A47 Blofield to North Burlingham

Scheme Number: TR010040

Volume 8
8.13 Statement of Common Ground
with National Highways
and Blofield Parish Council

Statement of Common Ground – Blofield Parish Council

|  | SUITABILITY |

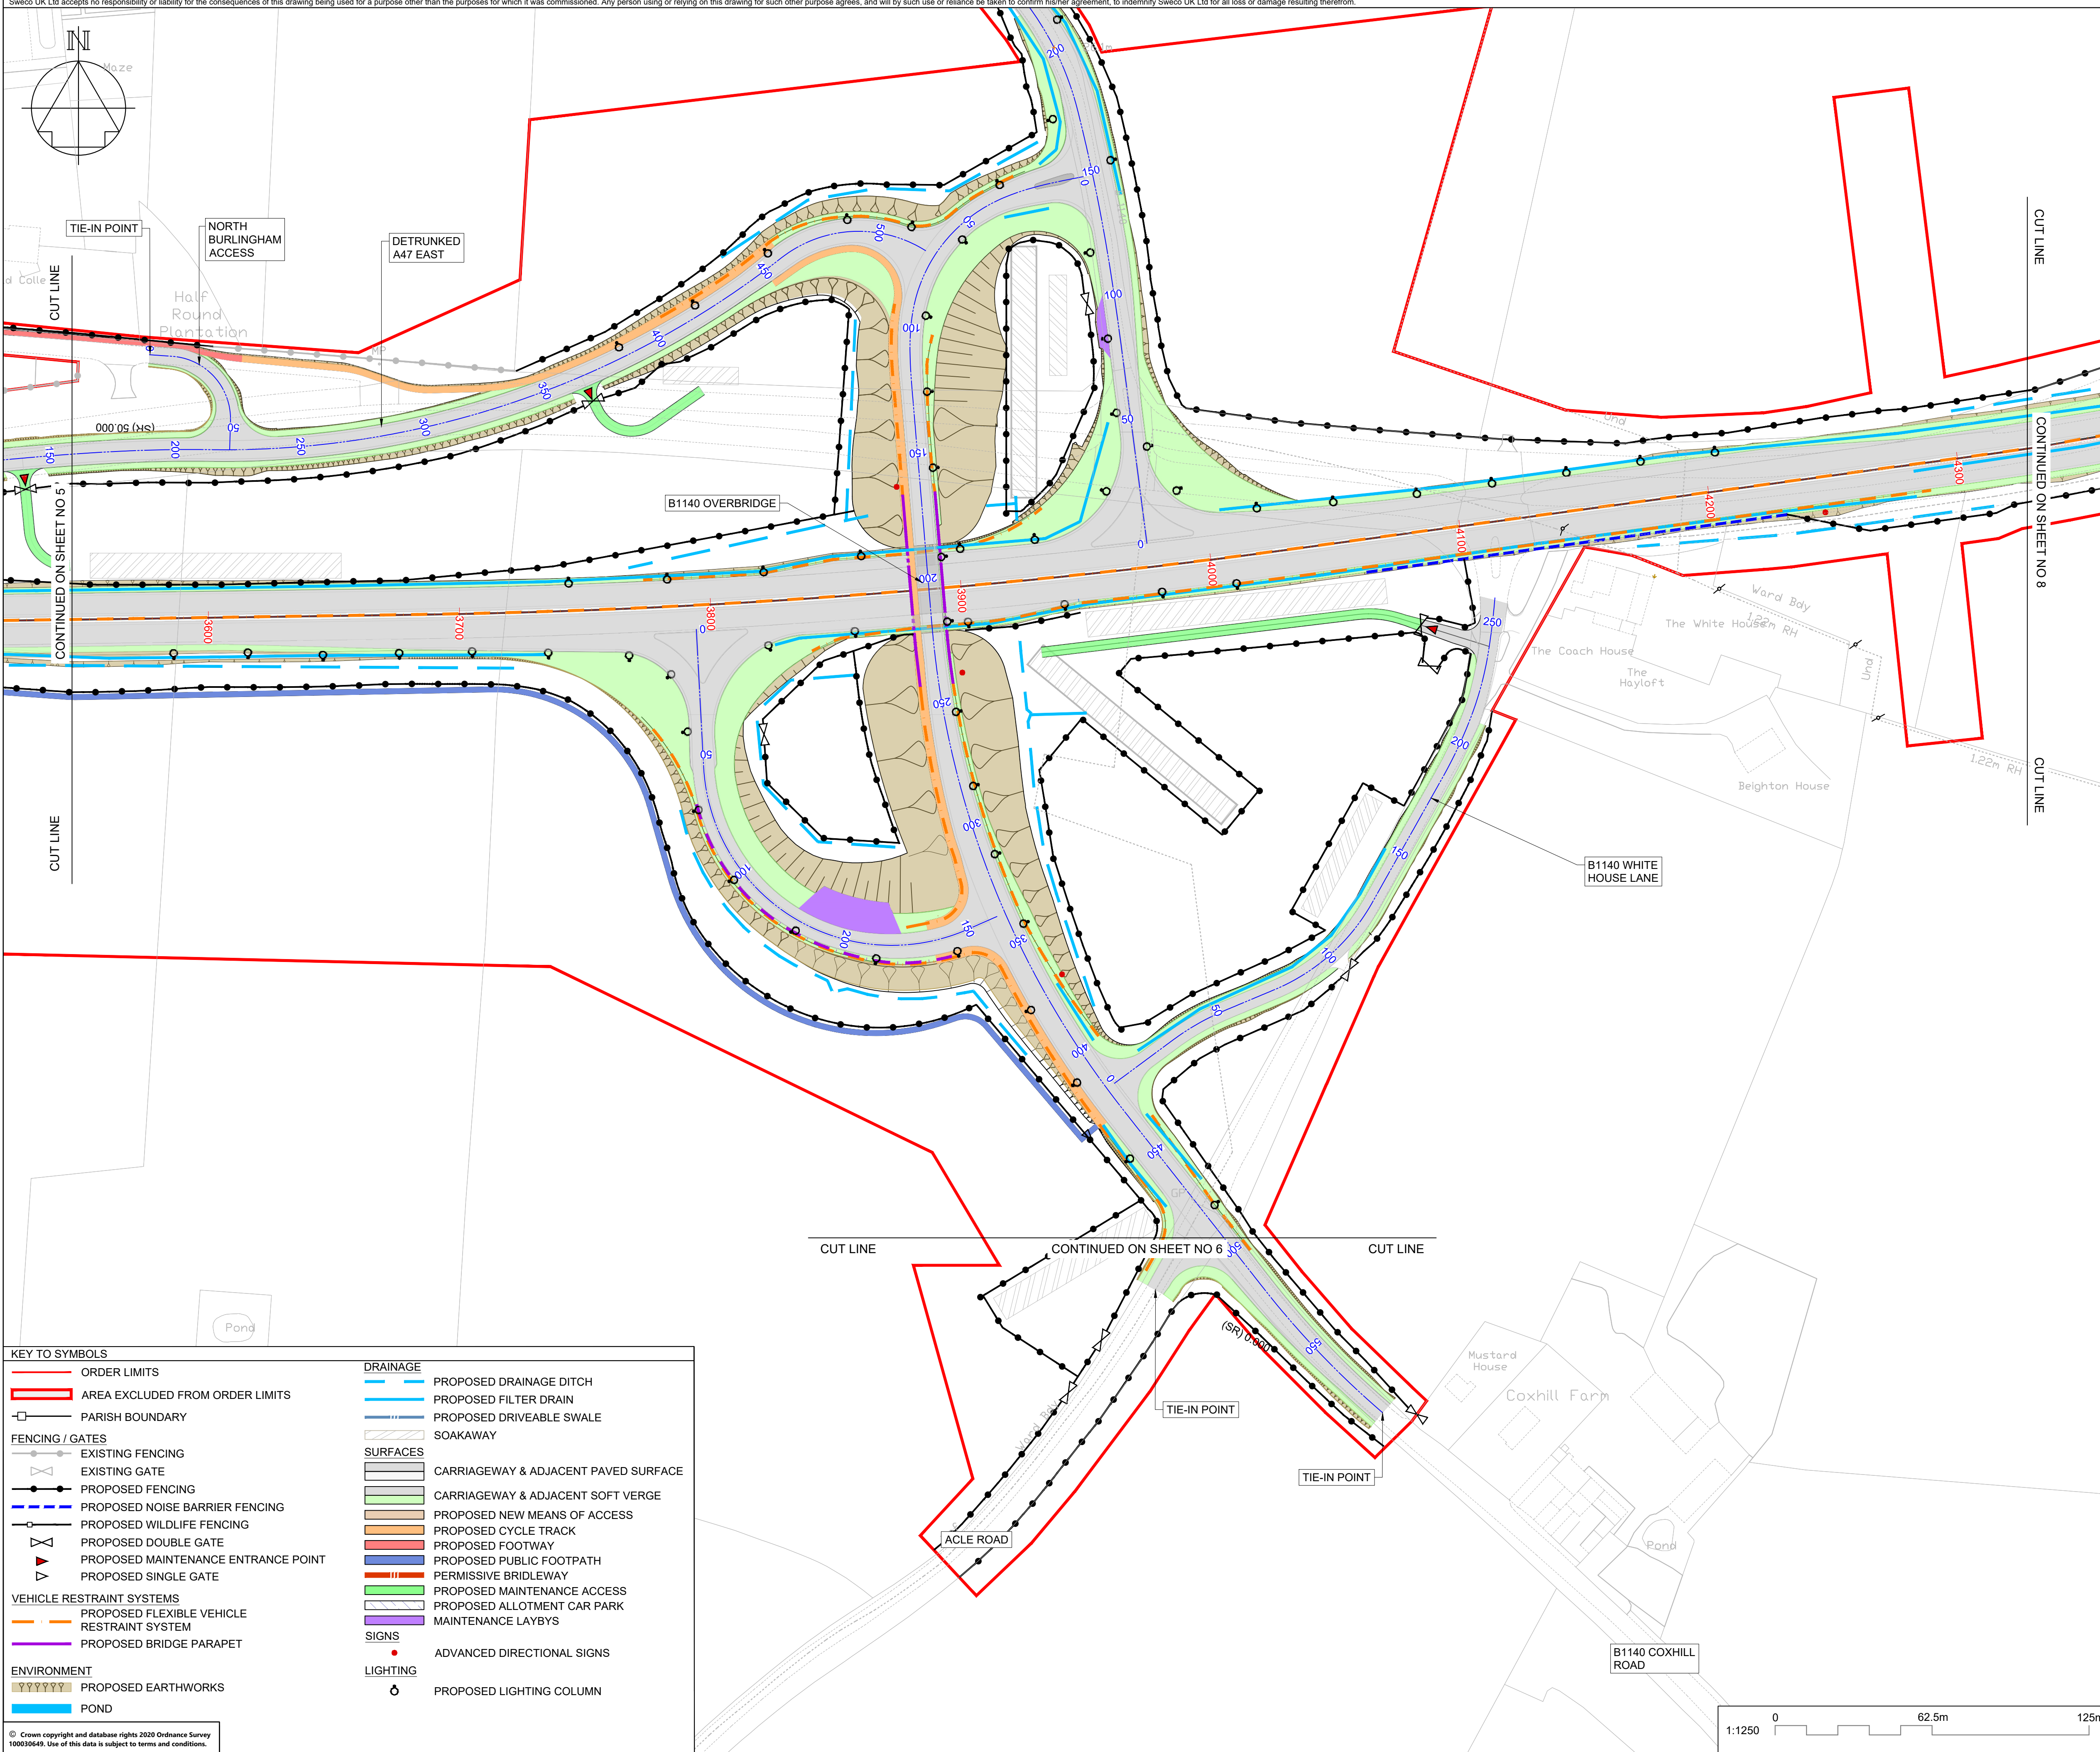
Road Lighting	Letter from BPC in Appendix C, Appendix H & Appendix I	2.6 General Arrangement Plans The proposed 20 lighting columns would be in contradiction of the Blofield Neighbourhood Plan Environment 5 Policy regarding Dark Skies. If the proposed junction was amended as per our suggestion at the beginning of this document, then the junction lighting would not be in contradiction to our local plan policy.	As described in the Scheme Design Report (REP1-046) lighting is proposed at the Yarmouth Road as road safety mitigation. The lighting will be LED and include back shields, where appropriate, to limit light spill. The modified junction arrangement as proposed by Blofield Parish Council is not a technically viable solution. Whilst Option B, considered in the Scheme Design Report (REP1-046) may not require lighting, it would have other environmental impacts resulting from the increased land take and additional construction.	Under discussion

Issue	Document Reference	Blofield Parish Council Comment	Applicant's Response	Status	Date
			The provision and assessment of lighting in the ES Chapter 7 (APP-045) and the Lighting Assessment contained in Appendix 7.8 (APP-085) assume the worst-case scenario and if alternative solutions can be found to improve the visibility of the junction without the need for lighting the lighting may be removed during detailed design.		
Road Lighting	Email from BPC in Appendix E	There are also a lot of street lighting columns which is against the dark skies policy of the council.	See response above regarding street lighting.	Agreed	11-Nov-21
Hedgerows	Letter from BPC in Appendix C	2.9 Hedgerow Plans The Council is disappointed that there appears to be limited new hedging being planted to offset the hedging being removed.	The hedgerows to be provided are shown on the Masterplan (REP7-011). The scheme results in a biodiversity net gain of greater than 40%.	Agreed	11-Nov-21
